From: Chantelle Bashford <Chantelle.Bashford@arun.gov.uk>
Sent: 17 November 2021 10:54
To: Planning.Responses <Planning.Responses@arun.gov.uk>
Subject: RE: Planning Consultation on: LU/315/21/PL

Please see comments below from Private Sector Housing concerning the change of use from a dwelling house to a 7-bed HMO.

Application No: LU/315/21/PL
Registered: 19th October 2021
Site Address: 12 Cornwall Road Littlehampton BN17 6EE
Grid Reference: 502760 102560

Description of Works: Change of use from (C3) Dwelling house to 7 bed House in Multiple Occupation (Sui Generis) (resubmission following LU/240/21/PL). This site is in CIL Zone 4 and is CIL Liable as a House in Multiple Occupation.

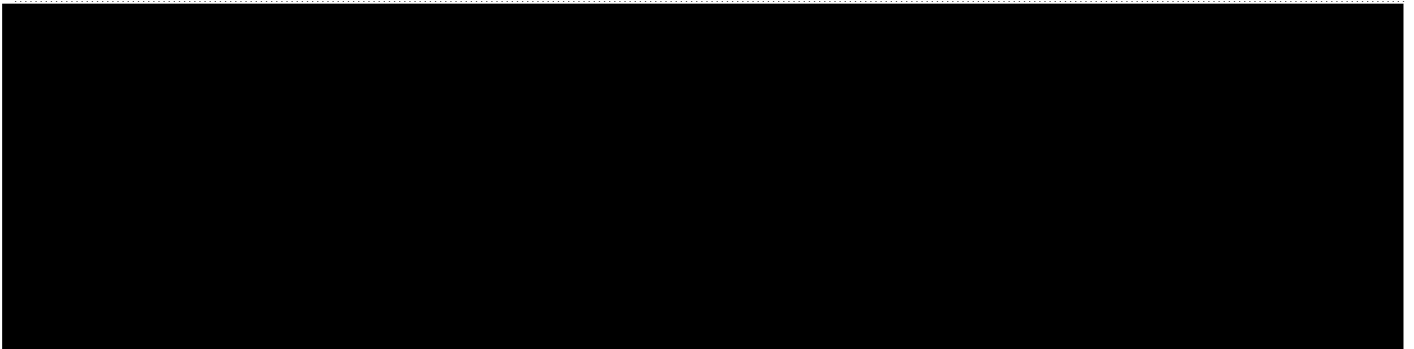
- Bedrooms 4 & 5 will become inner rooms, but this has been acknowledged on the proposed plans as alternative means of escapes are provided.
- The ensuite bathroom to bedroom 4 does not appear to be of an adequate size or layout. Bathrooms must be of an appropriate size to provide adequate changing and drying space for the users. The proposed plans show this bathroom to be of the same width as the shower tray which is likely to restrict the movement of the user. For example, the user is likely to collide with the walls on either side when stepping out of the shower and attempting to dry themselves or get dressed. In addition to not meeting the HMO Standards, this is likely to be identified as a hazard under the Housing Health and Safety Rating System (HHSRS).
